Application No: BR/20/26/PL

Recommendation Report for Planning Permission

LOCATION: 51a Aldwick Road
Bognor Regis
PO21 2NJ

PROPOSAL: Retention of change of use of first and second floor office to a 5 bed HMO. This application is in CIL Zone 4 (Zero Rated) as other development.

TITLE
Block Plan

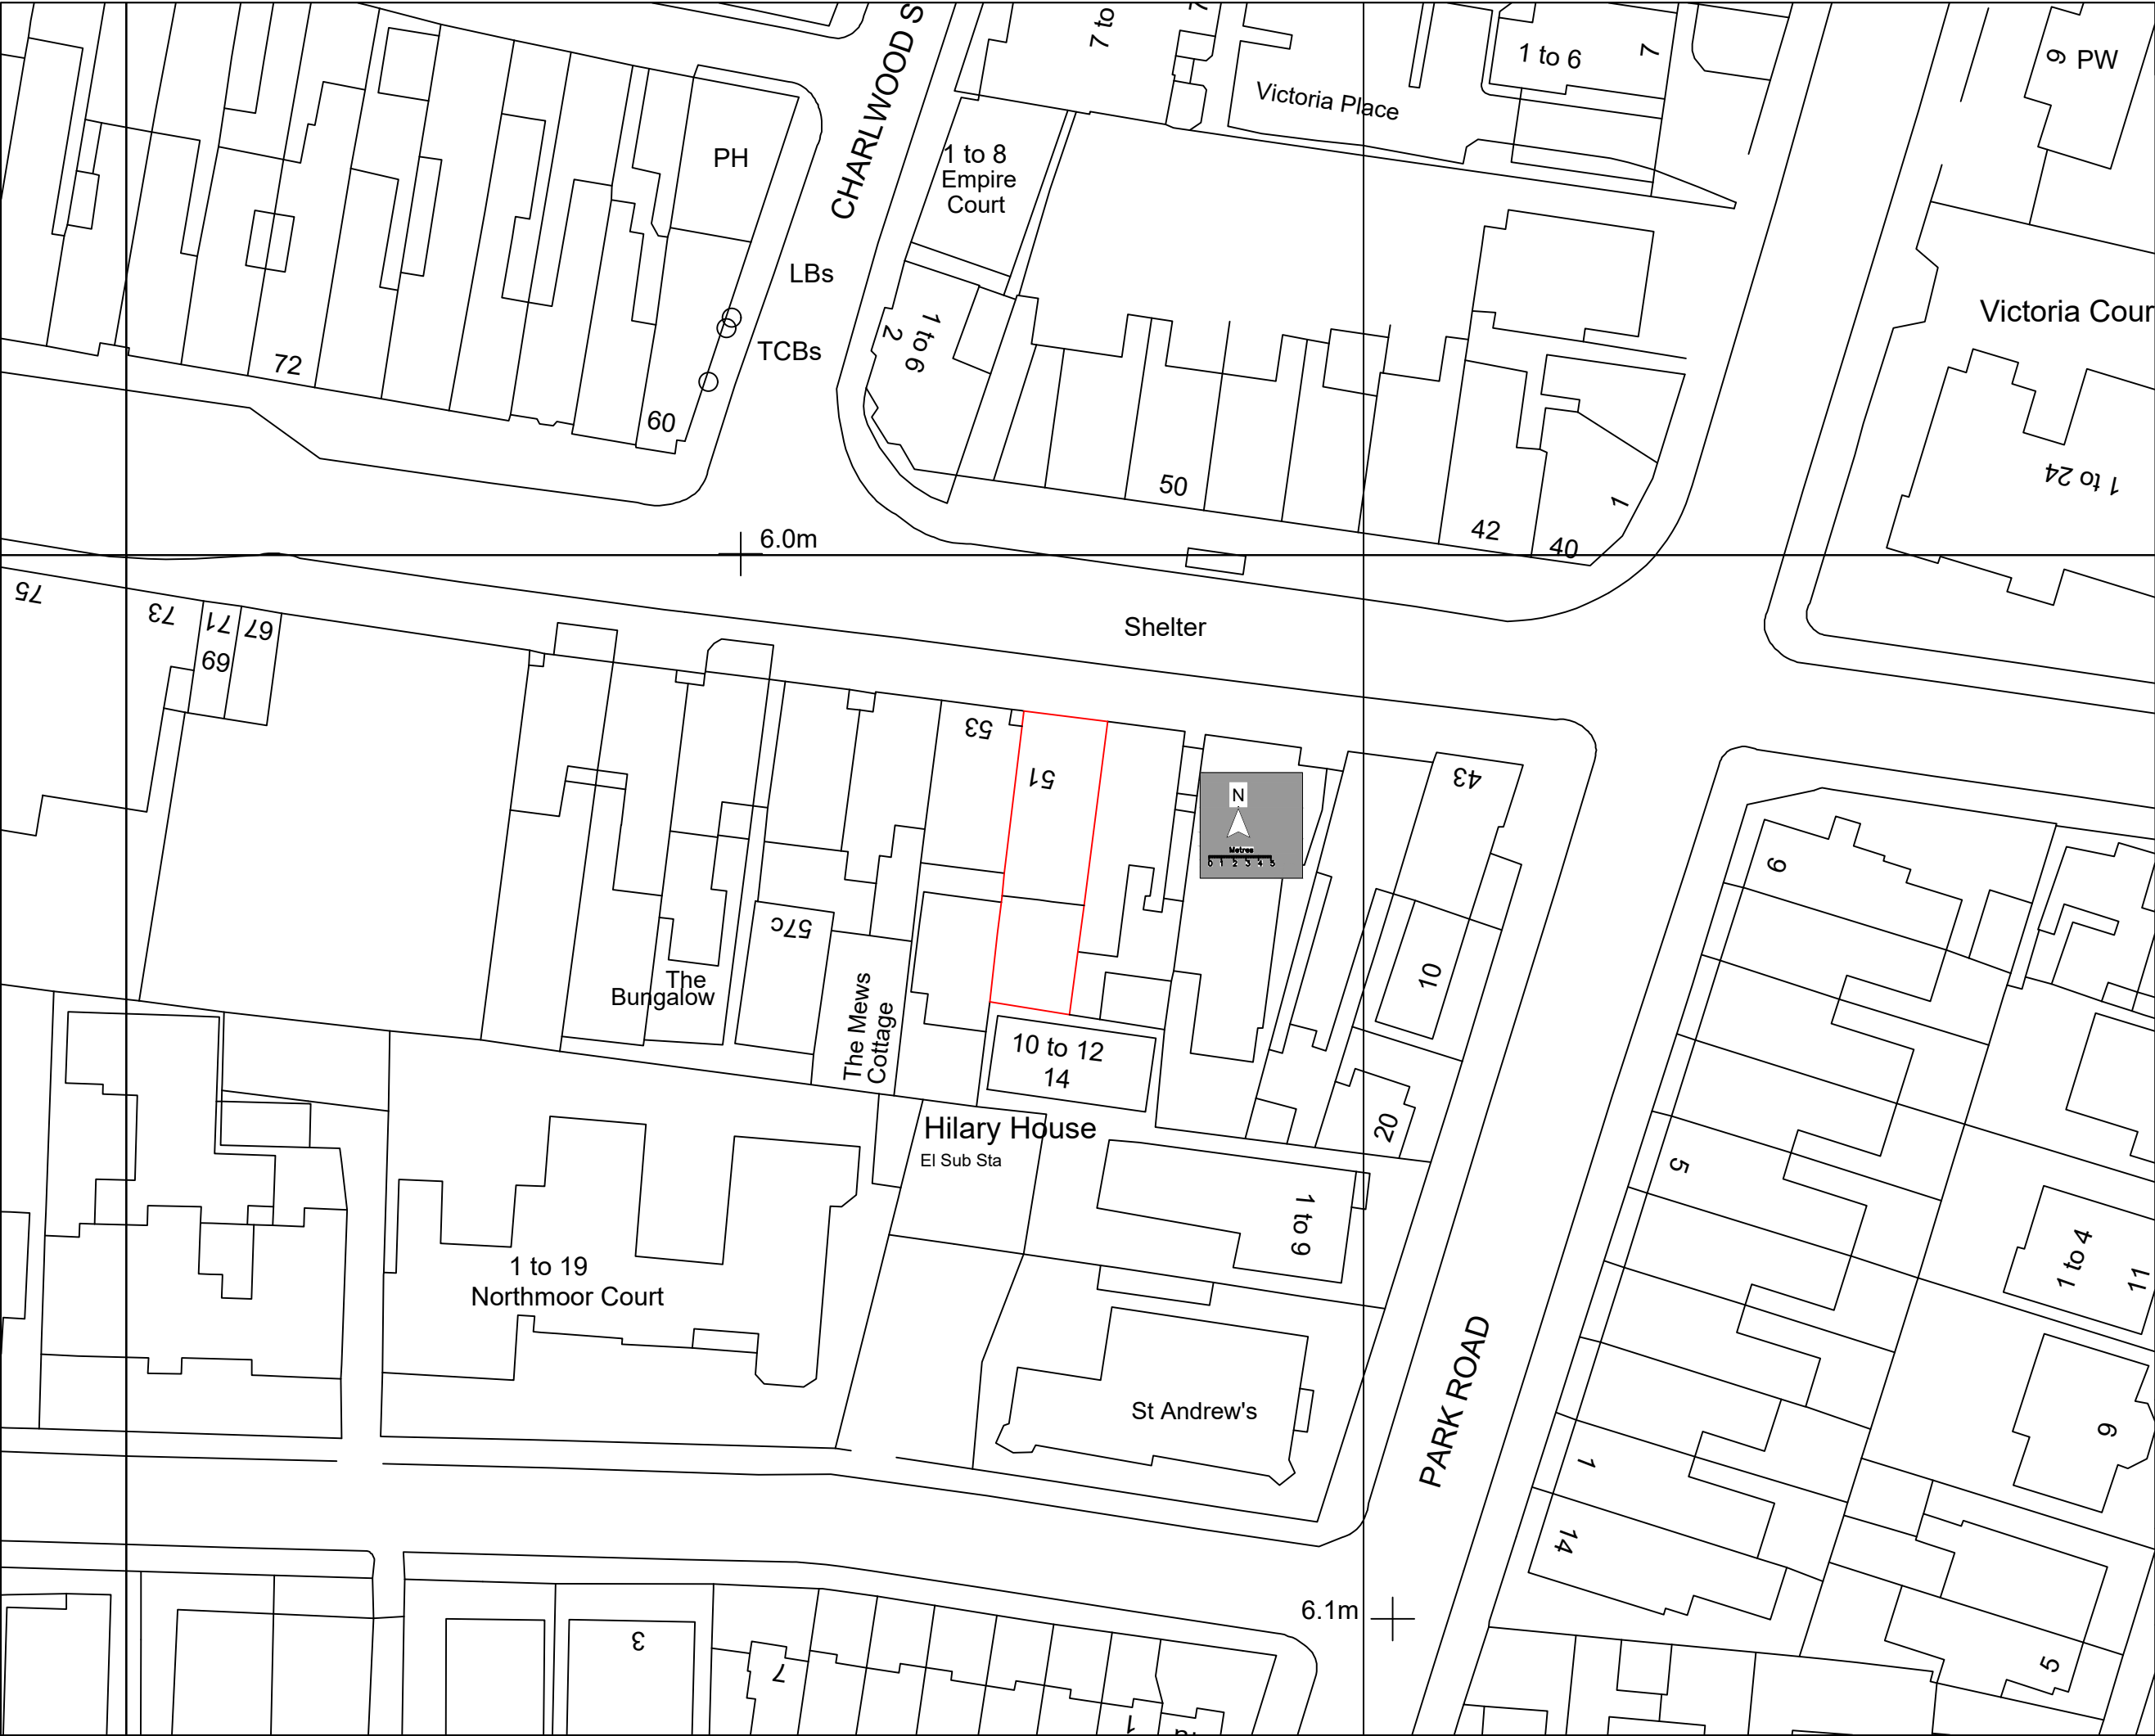
The proposal provides external amenity space to the rear of the ground floor commercial unit. Section H of the ADG states that communal shared spaces, such as shared external amenity space, should be a minimum of 40sqm, plus 10sqm for each unit. The Local Planning Authority typically consider that every three rooms in an HMO constitutes one unit. The proposals would require approx. 60sqm of communal external amenity space. The area of the rear garden is approx. 59sqm, which is adequate. The site is in close proximity of public open spaces, in particular the sea front and gardens adjoining this area.

The proposal is for residential accommodation which would be above an existing shop, and the lack of parking provision would not be uncommon for this type of development. On street parking is restricted immediately to the front of the property, however, some on-street parking would be available within the vicinity on roads to the north and south of Aldwick Road. Provision of secure and covered cycle parking on the site would be difficult, as there is no access to the external amenity space other than via the first floor HMO. The provision of cycle parking is not practical in this instance.

Reason for Update/Changes: Comments received from WSCC Highways, raising no objection to the proposed change of use. A condition has been recommended requiring the provision of secure and covered cycle parking. As outlined in the report, provision of cycle parking spaces within the site is not feasible as there is no easy access to the rear garden, and therefore it is not recommended that the condition is added.
